Re: Significant Development: Fort Street Public School Application No SSD-10340 – Mod 1

Submission from Observatory Tower

/ S4.55 - South West View

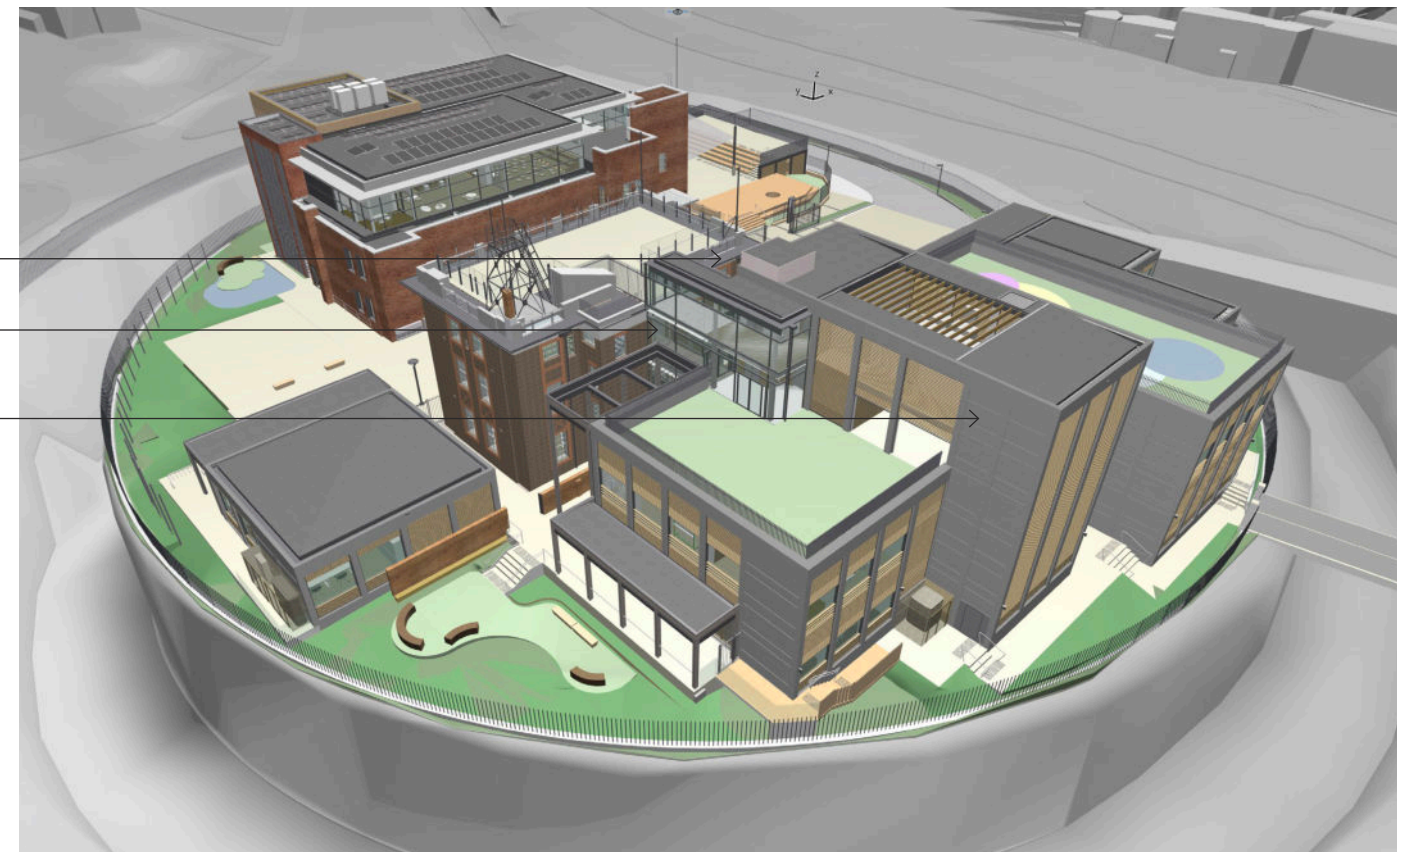
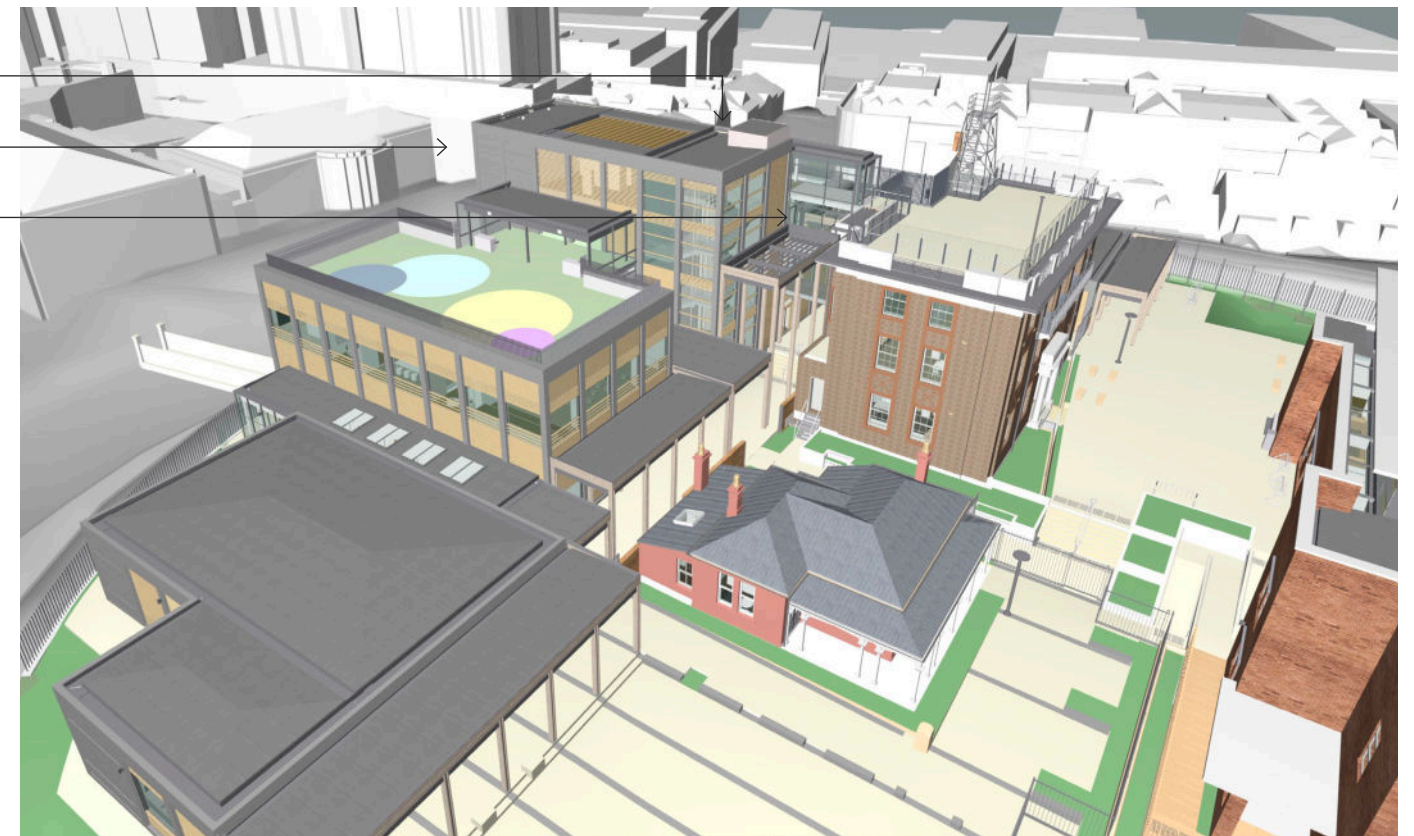
Now however, the Department has circulated a modification **Mod-1** (the subscript 1 sounding ominous) proposing that Building J, will be set at a **height one floor higher than the current Meteorological (Met) building**.

2. **Violation of original proposal and CMP.** The original HIS and CMP required for good reason that no building be higher than the Met building. The modification proposal VIOLATES this self-imposed and important requirement, failing to meet **the CMP accepted for the site.**
